**Land south of Water Lane, Angmering
Submission of Minor-Material Amendment (Section 73) Pursuant to Detailed Planning Permission
Ref. A/24/21/PL.**

Please find enclosed details pertaining to a Minor-Material Amendment (Section 73) to amend Condition 2, Condition 3 – Approved Plans, Condition 5 – Flint Wall and Condition 6 - Landscaping on Detailed Planning Permission Ref. A/24/21/PL.

**Erection of a temporary sales cabin with 4 parking spaces and associated landscaping. CIL
Zone 1 - This application is zero rated as temporary building.**

LGCHA023

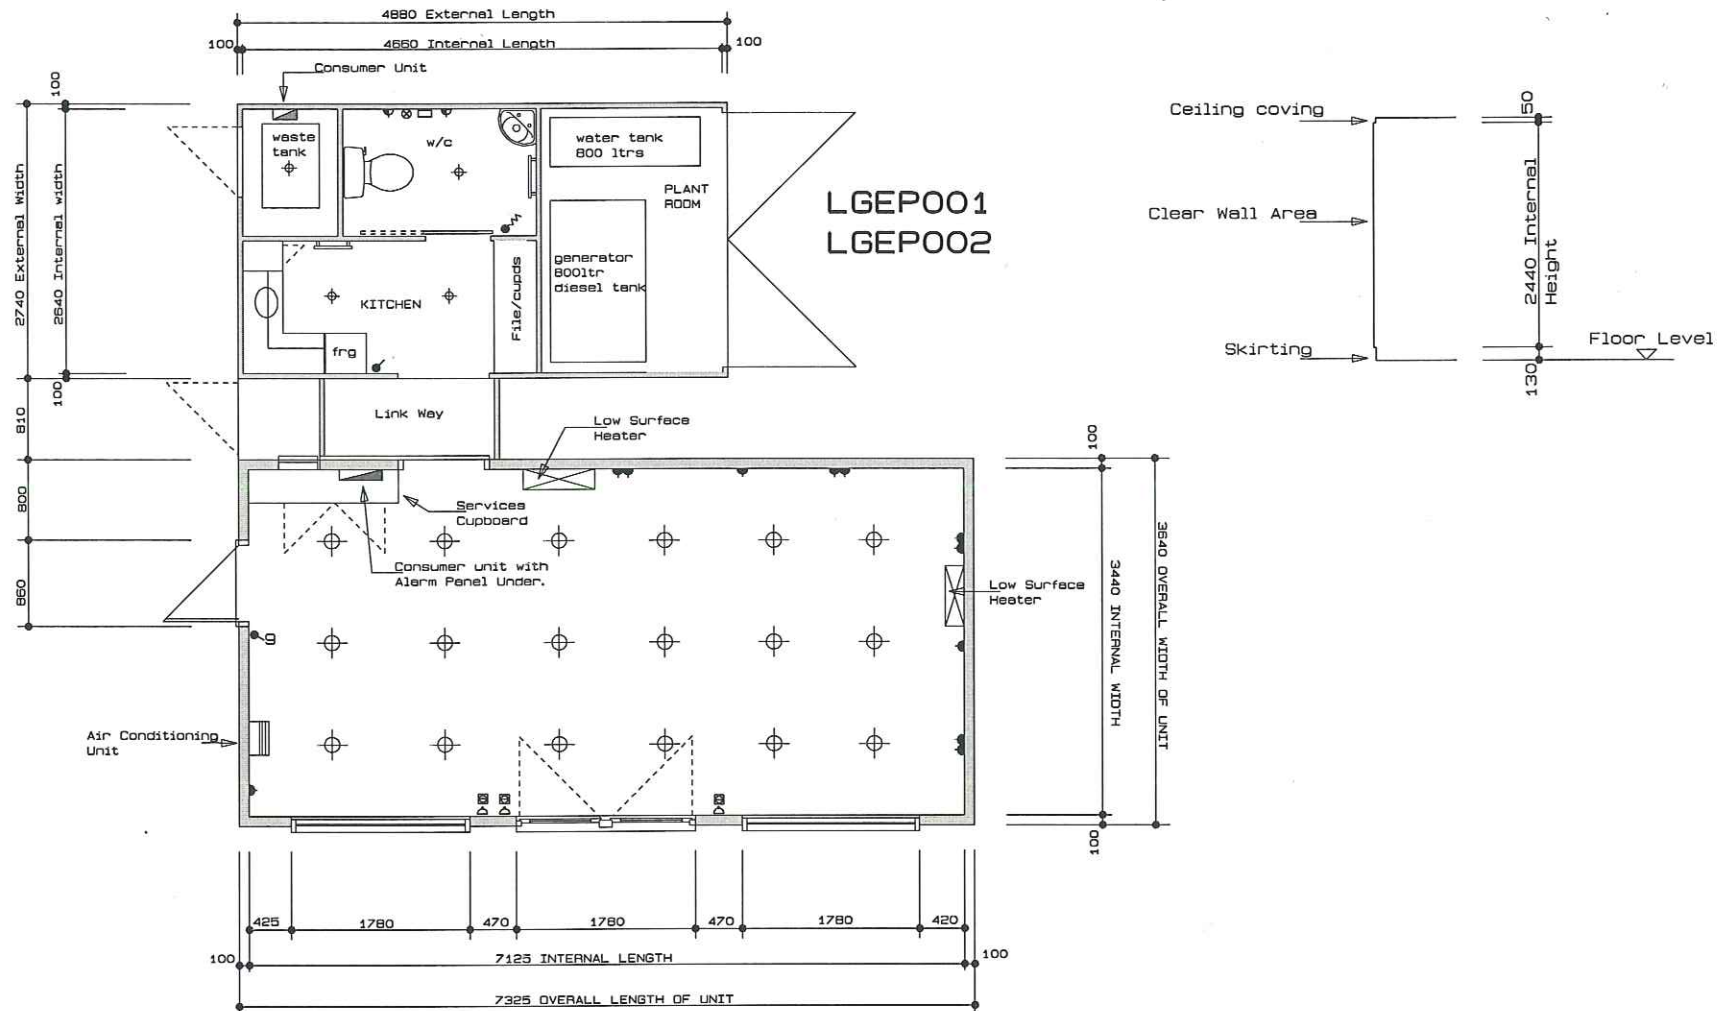
- 1. P1320.SALES.01 Rev. C – Sales Area Layout**
- 2. LGCHA023 ELEVATION & LAYOUT**
- 3. PLN-1-5009 Rev. C (JBA 19/283/09) – Detailed Soft Landscape Proposals for Sales Area**
- 4. Revised Design and Access Statement: Land South of Water Lane, Angmering – Temporary Sales Cabin, dated 22nd October 2021**

Scale	1:200 @ A2	Drawn	DGP	Checked	DGP
Date	November 2020	File	P1320 Sales Layout	Drawing Status	
Drg.No.	P1320.SALES.01	Rev.	C	PLANNING

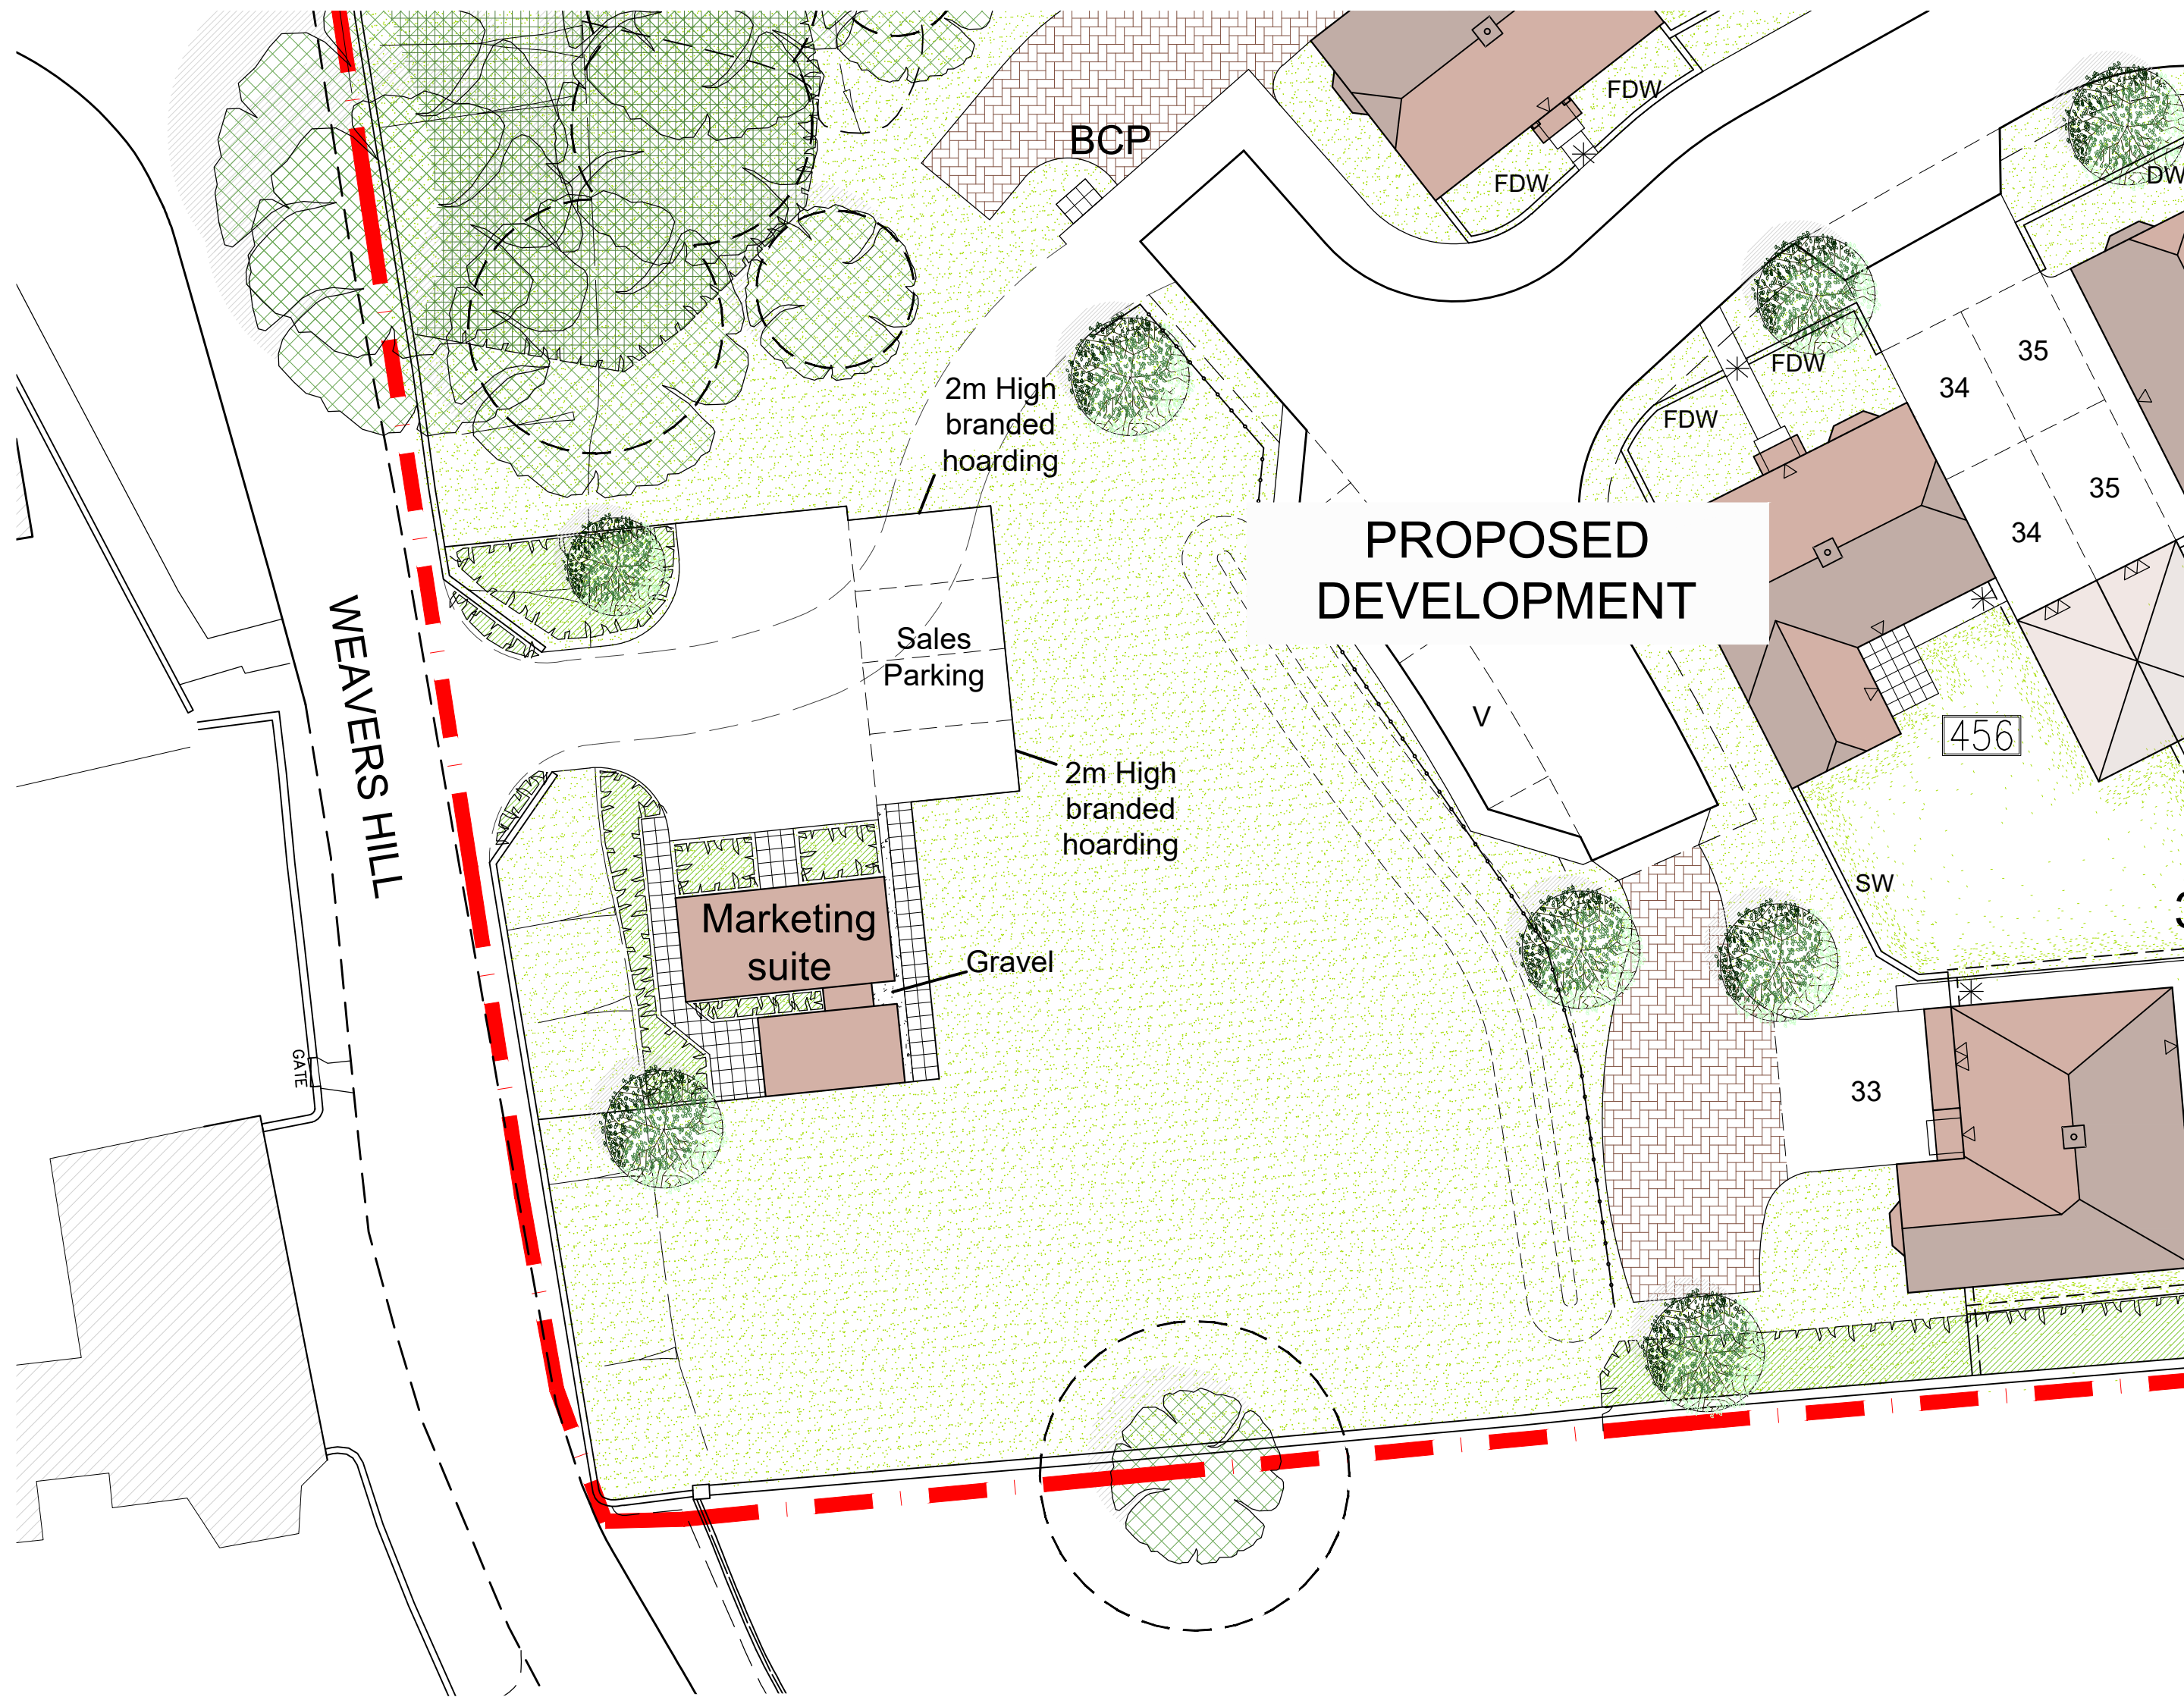
Our sales and construction teams upon attending site to undertake the relevant works made a number of changes to improve the design and appearance of the sales area. This primarily included changes to the planting scheme. Further changes were made from a health and safety perspective, incorporating greater amounts of paving and hard-standing to allow access to the power pack at the rear of the sales cabin.
